Waterbury Filing Nos. 1 and 2
 Traffic Impact Analysis
 PUDSP215 SF237 2
 (LSC #204220)
 July 20, 2022

LSC Responses to TIS Redline Comments (on the PUD Study)

RE: Waterbury Filing Nos. 1 and 2
El Paso County, Colorado
Traffic Impact Analysis
PUDSP215 SF237
LSC #204220

Figure 11  
**2030 Total Traffic,  
Lane Geometry and Traffic Control**  
Waterbury Filing No. 1 (LSC #204222)

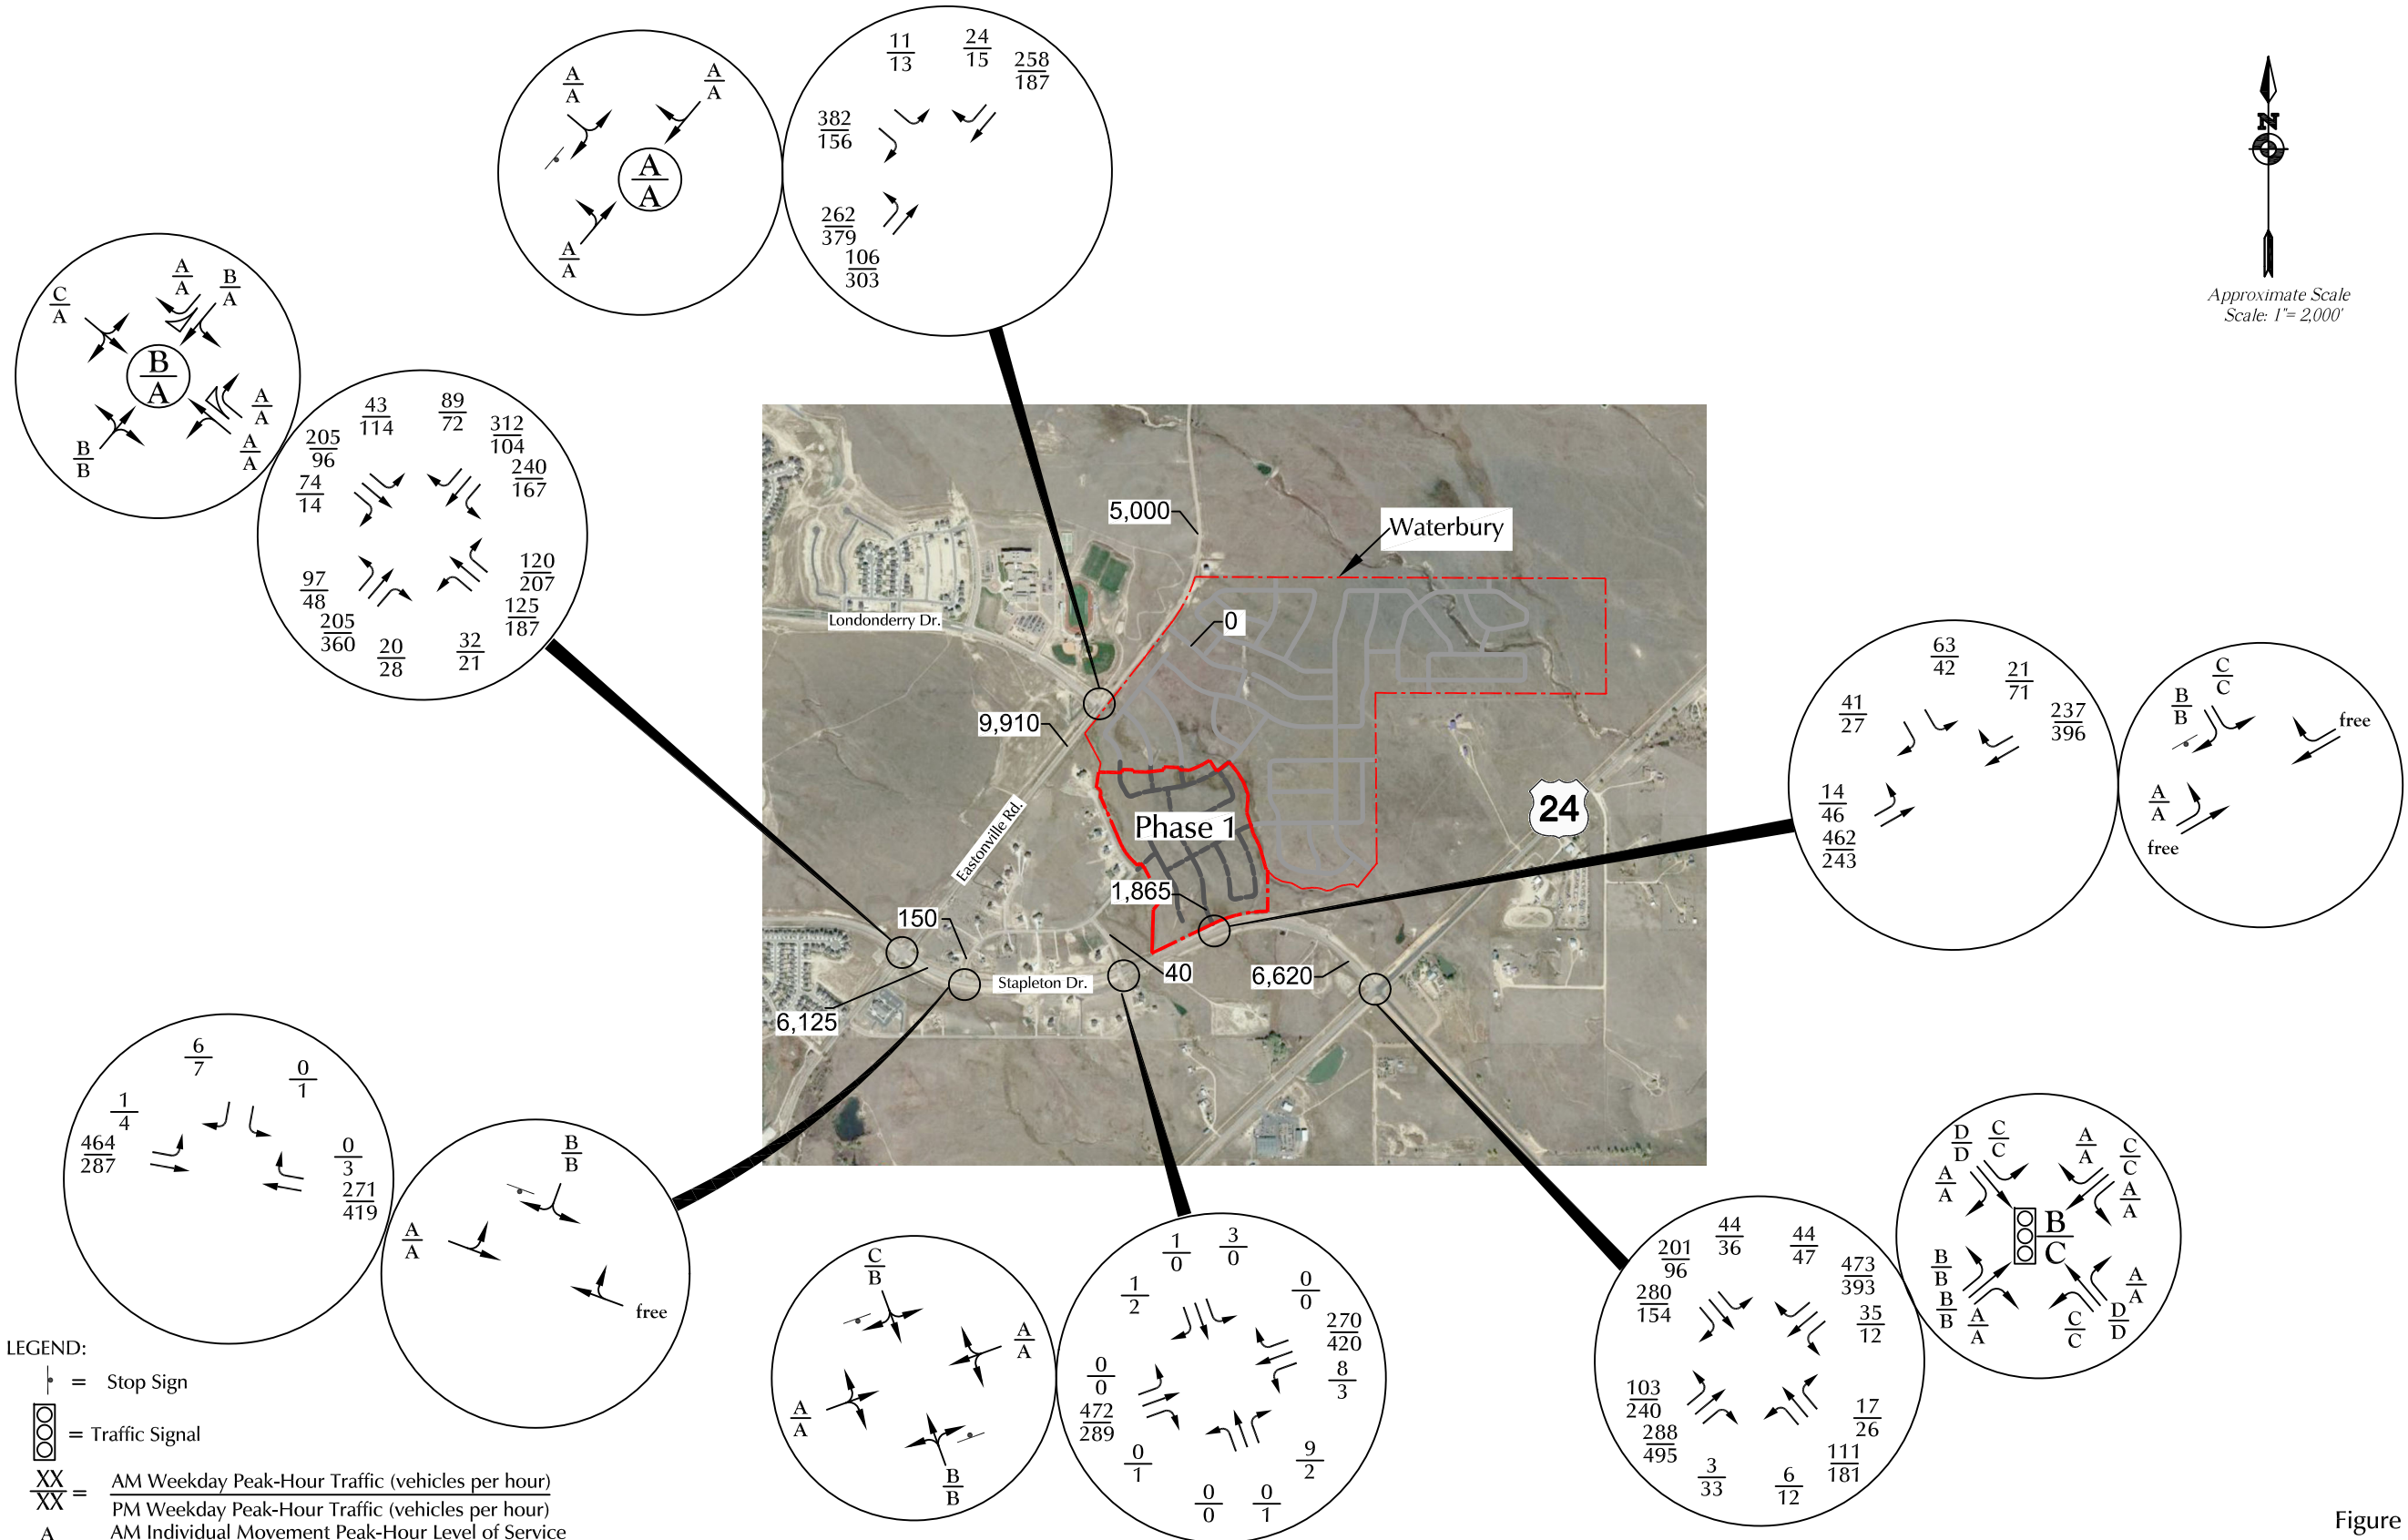
Number: 1 Author: CDurham Subject: Highlight Date: 4/27/2023 08:57:14
2021)

LSC Response: The short-term year has been updated to 2030

Figure 12  
**2045 Total Traffic,  
 Lane Geometry and Traffic Control**

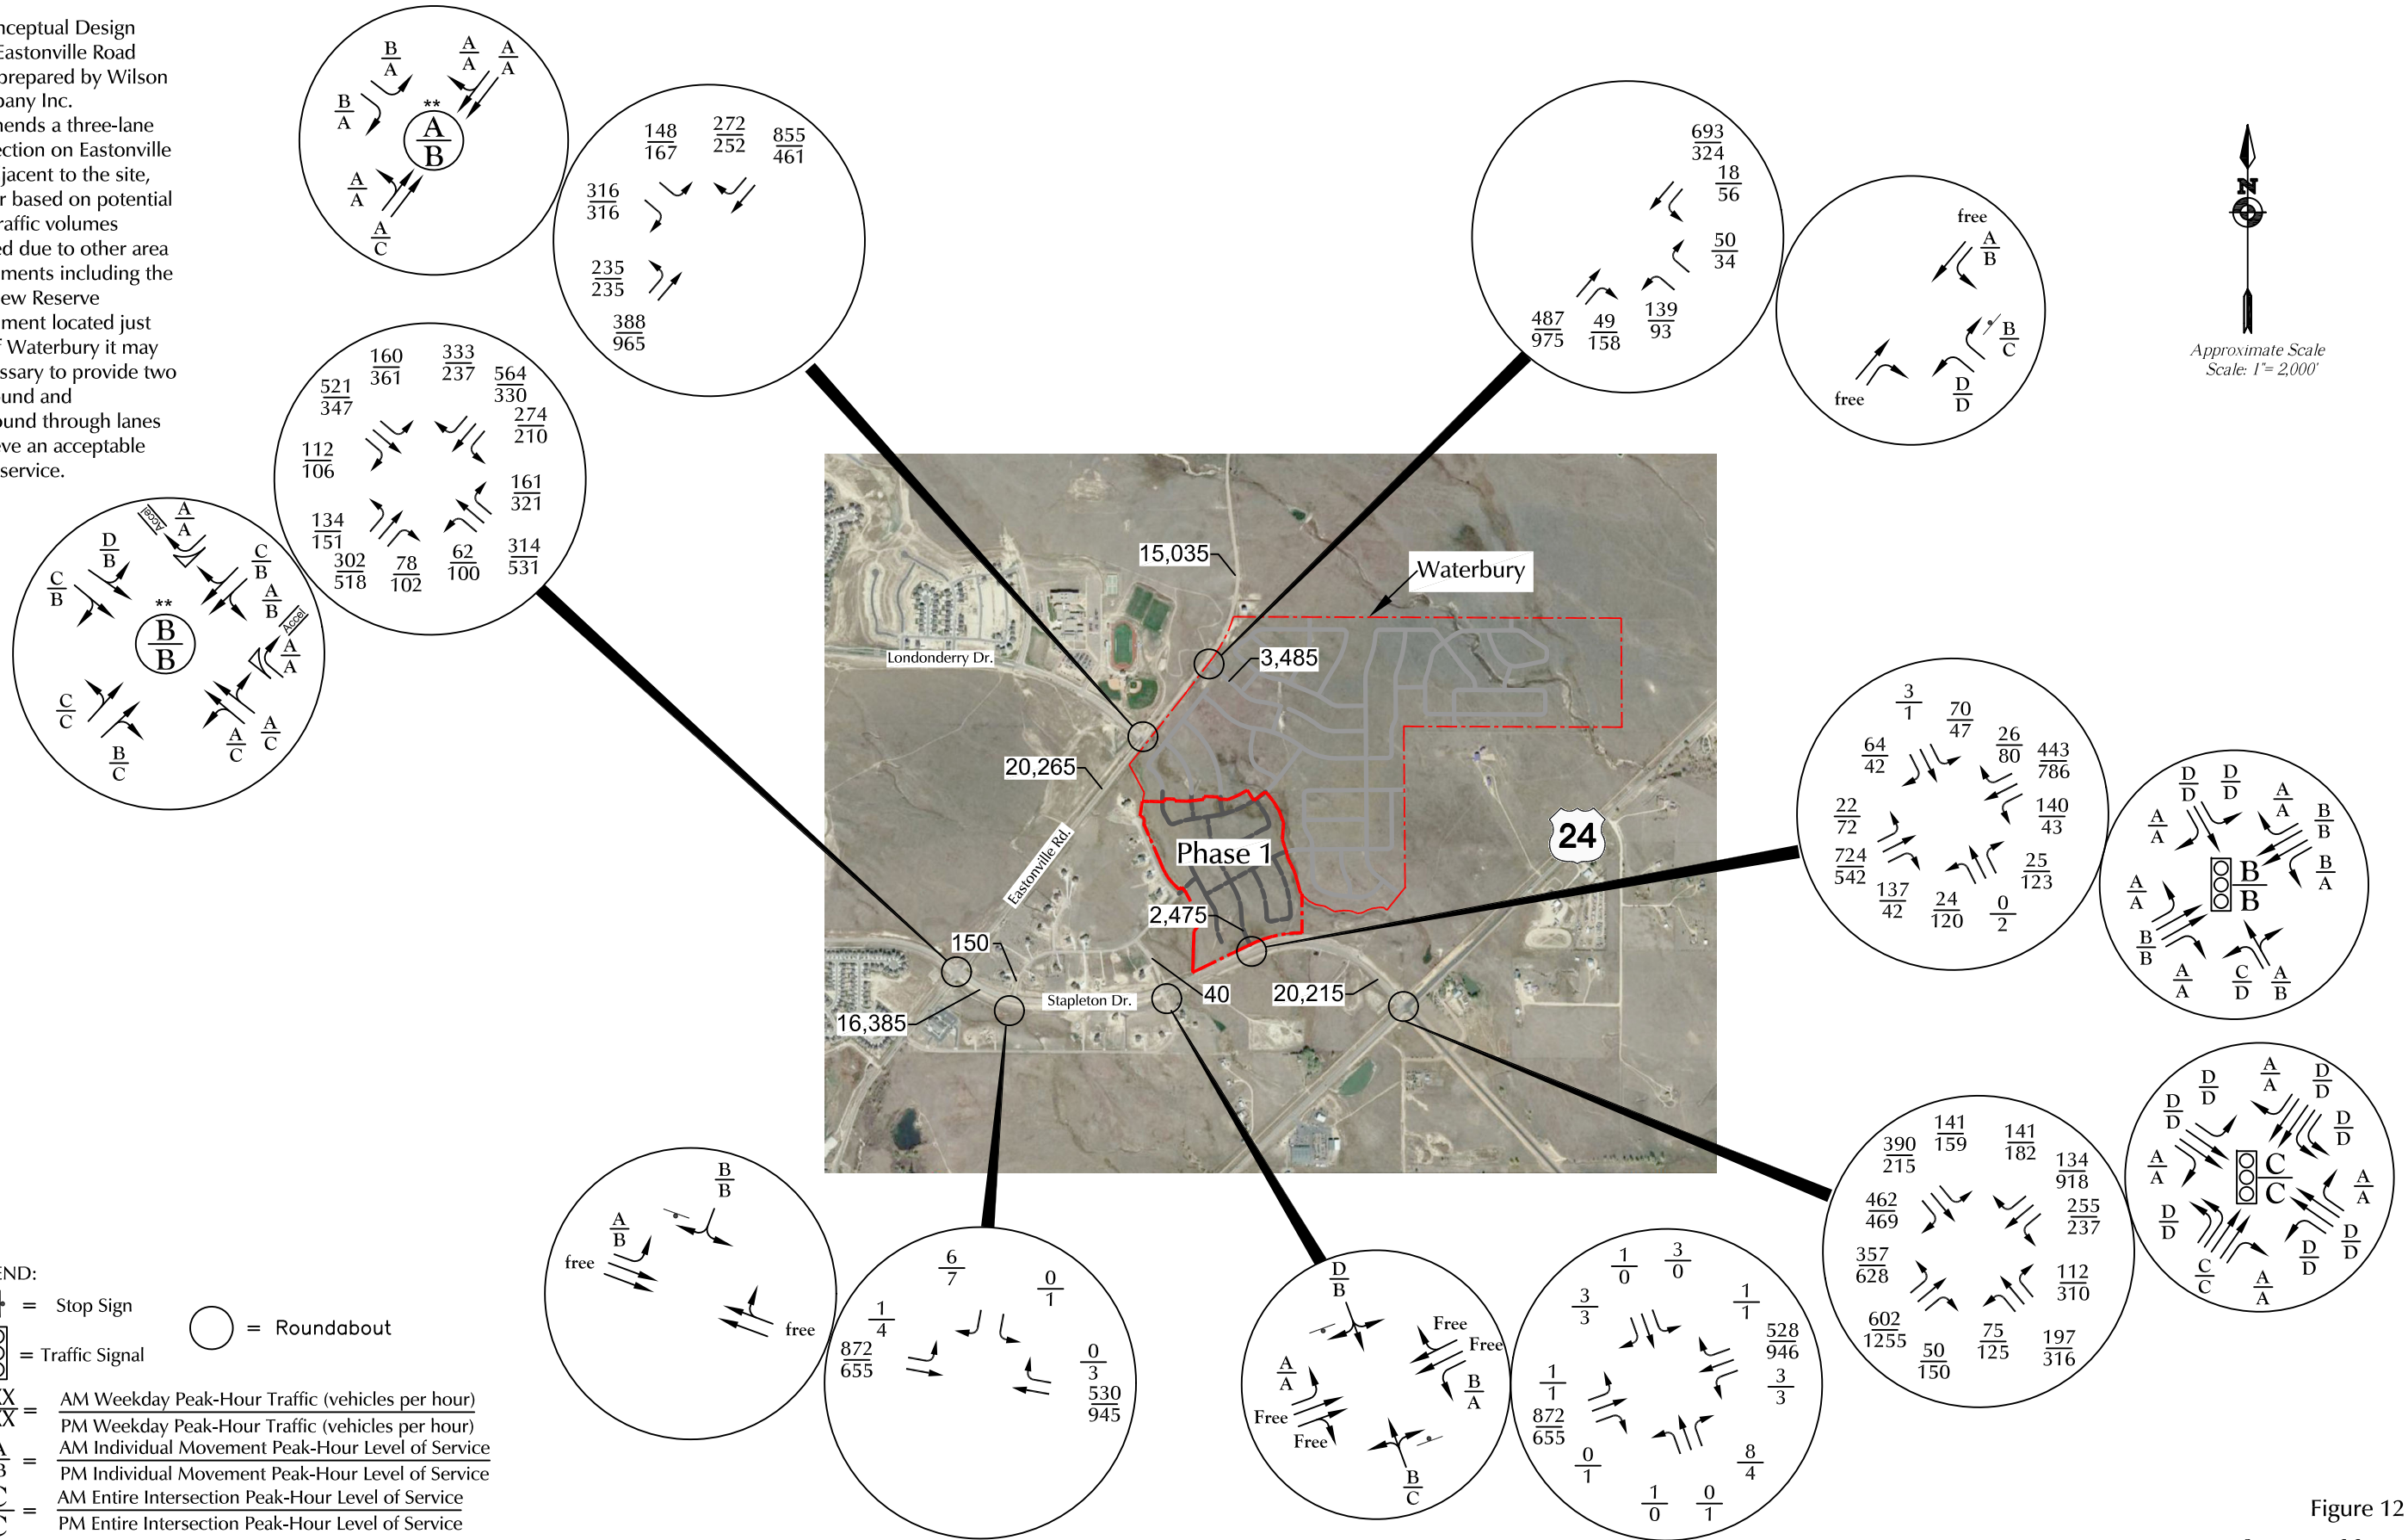
Number: 2 Author: CDurham Subject: Highlight Date: 4/27/2023 08:57:25
d 2040

LSC Response: The long-term year has been updated to 2045
